M25 junction 10/A3 Wisley interchange

TR010030

**10.11 Schedule of Proposed Amendments to dDCO in
Consequence of Proposed Scheme Changes**

Version	Date	Status of Version
Rev 0	11 February 2020	Request for change

Drawing Title	STREETS, RIGHTS OF WAY AND ACCESS PLANS REGULATION 5(2)(k) SHEET 4 OF 31
Drawing Number	TR010030/APP/2.4
Rev.	1
HE PIN: HE551522	Scale: 1:1000
Original Size: A1

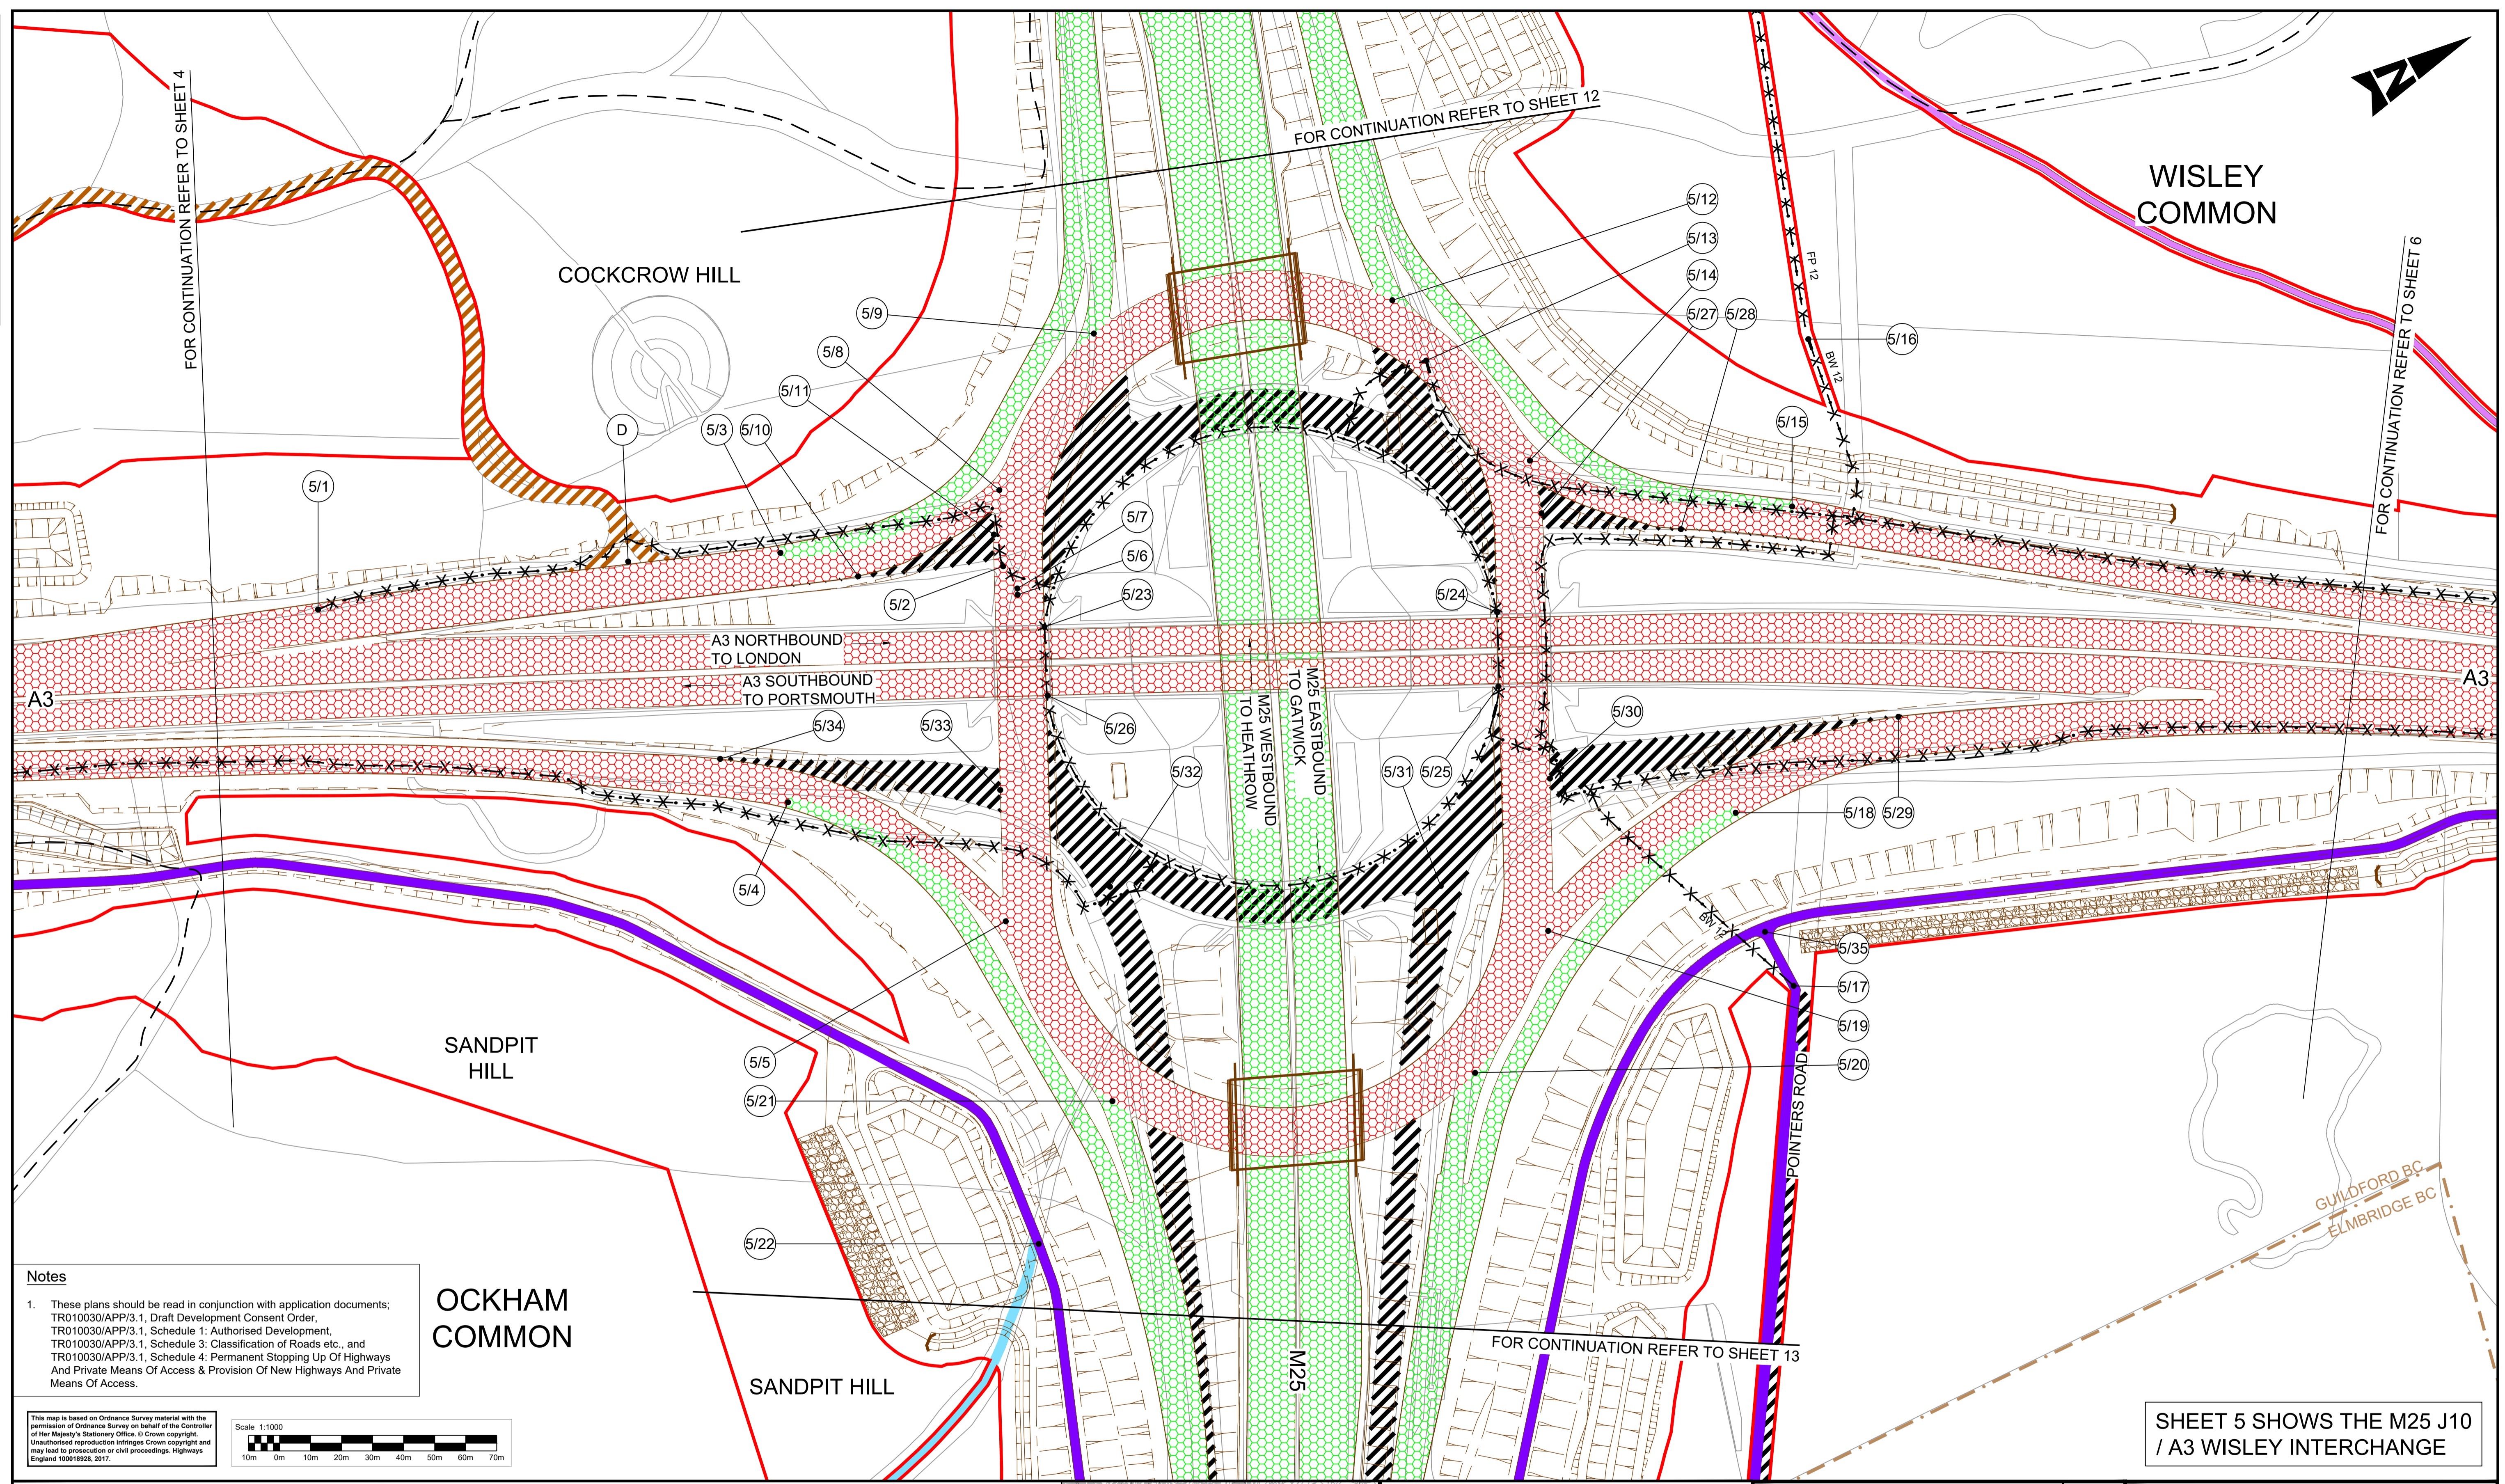
In the column (2) entry in respect of ‘Footpath’ in the fifteenth row on page 78, omit existing text and replace with “70 metres of footpath, as shown between points 4/9 and 4/14 on Sheet 4 of the Streets, Rights of Way and Access Plans.

Comment: These amendments are consequential on the extension of the green element to the proposed Cockcrow replacement overbridge.
